City of Albuquerque Stormwater Construction Site Inspection Report

ESC File No.	H14E111	Project Name:	Phoenix Apartments		
NPDES Id. No.	NMR10047E	Location:	2818 4th St. NW		
8/25/2022	Owner	Contractor - NMR1047P			
Operator	Michael Dreskin	J&S Development			
Contact name & title	Michael Dreskin	Jose Rodriguez			
e-mail	mdreskin@aol.com	rodriguez3003@hotmail.com			
Contact Phone #	249-7788	440-5104			
COA Inspector	Doug Hughes	Start/End Time:	10:30-11:30am		
Construction Phase:	Staging				
Type of Inspection:	<input checked="" type="checkbox"/> Regular	<input type="checkbox"/> Storm Event	<input type="checkbox"/> Past Storm Event >0.25"	<input type="checkbox"/> 311/Complaint	<input type="checkbox"/> Follow Up
Weather at time of inspection?		Clear		Temperature: ~ 75	
Estimated date of last storm 0.25" or greater		6/26/2022

TEMPORARY EROSION AND SEDIMENT CONTROL PLAN

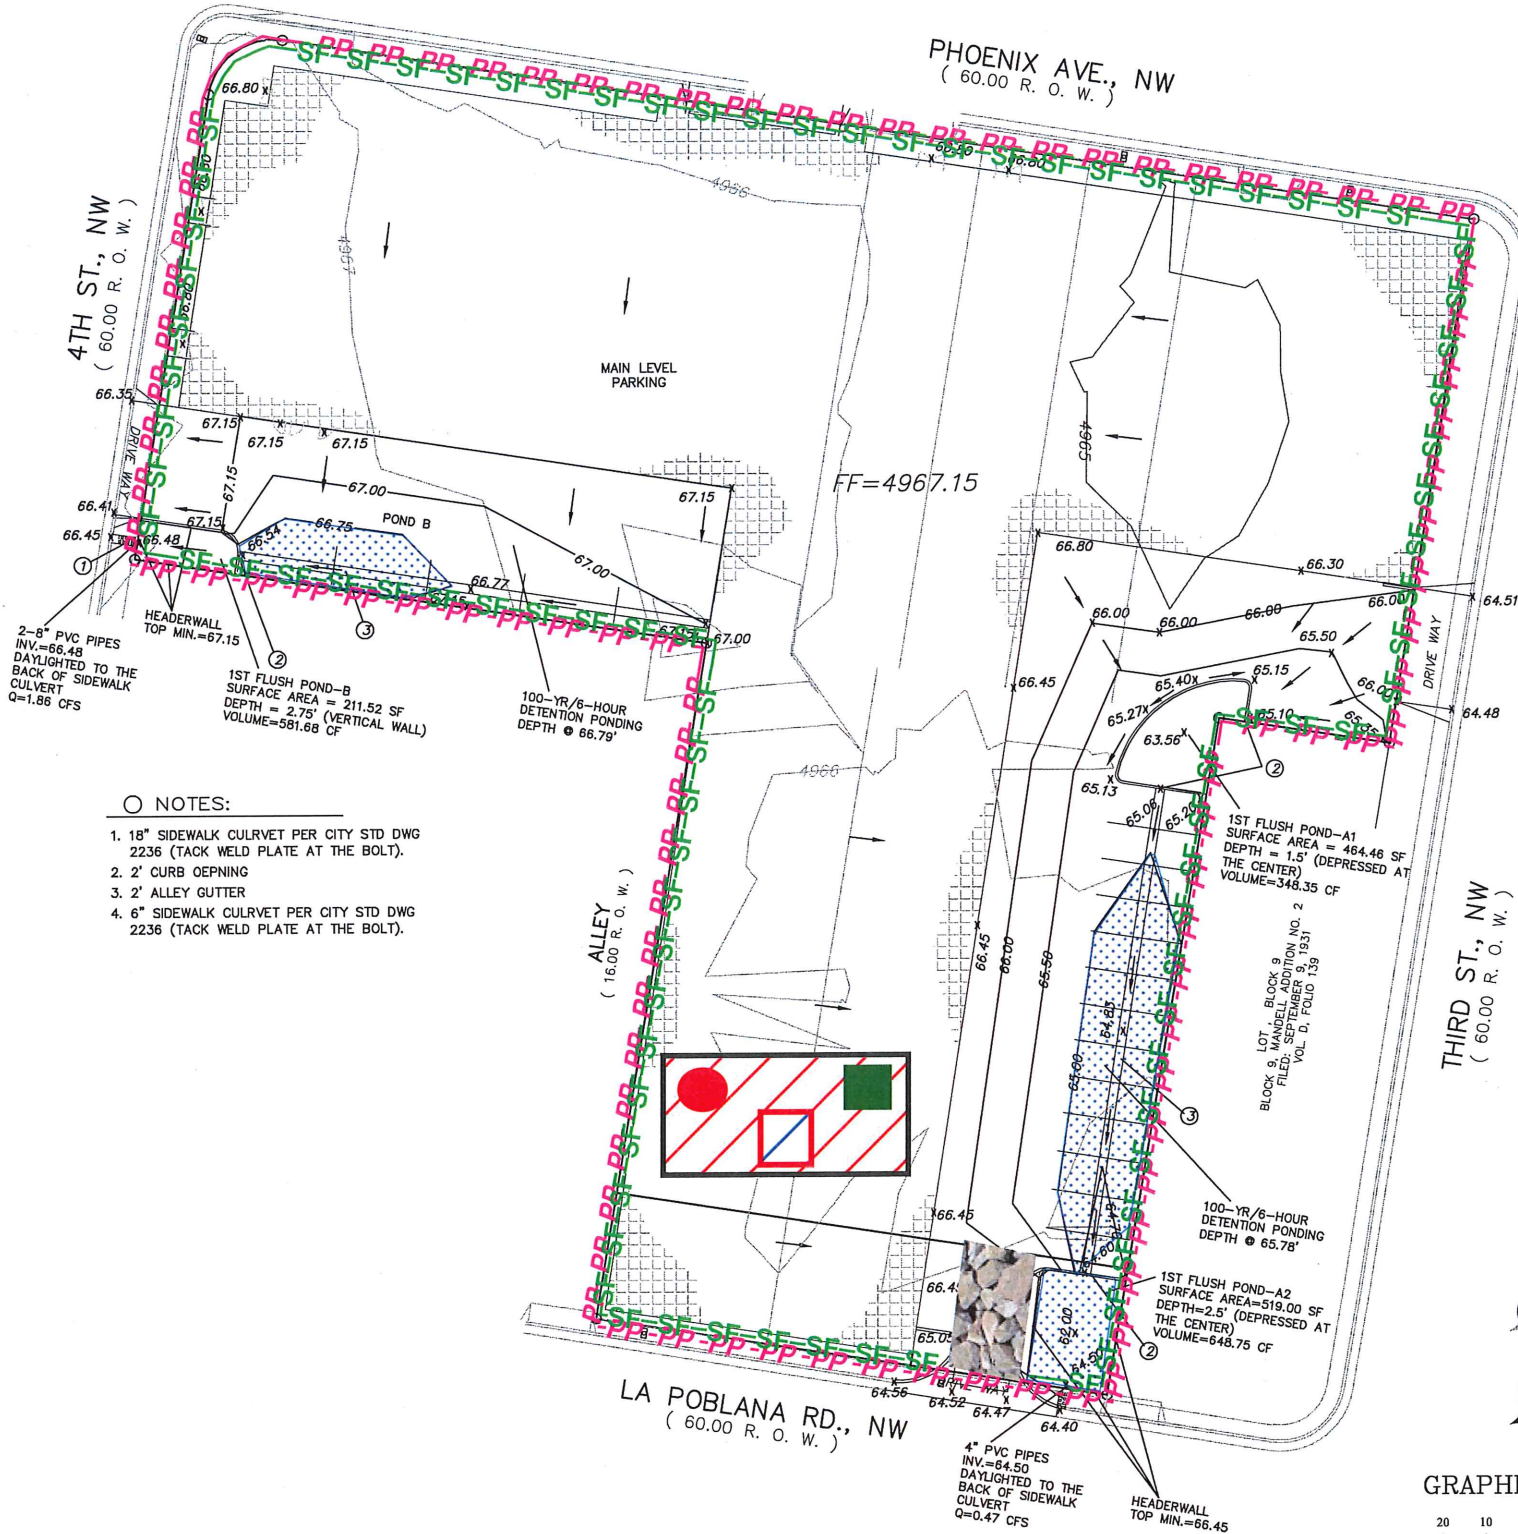
Item Number	Deficiency/ Corrective Action				
1	The SWPPP wasn't up-to-date at the time of inspection. Self Inspection Reports and Corrective Action Logs were missing.				
2	The 2017 CGP and NOIs were still not updated to 2022 permits. 2022 CGP and NOIs missing.				
3	Concrete washout container was covered by trusses and non-functional. Reset the washout and direct wash water from concrete, paint, and stucco into a leak-proof container per CGP 2.3.4.				
	Discharge off site? (Y/N)	no			
4	Self Inspection Reports	required	Latest report Date:	8/18/2022	
Notes:					
The SWPPP is in conex box in new building. Call Jose 440-5104.
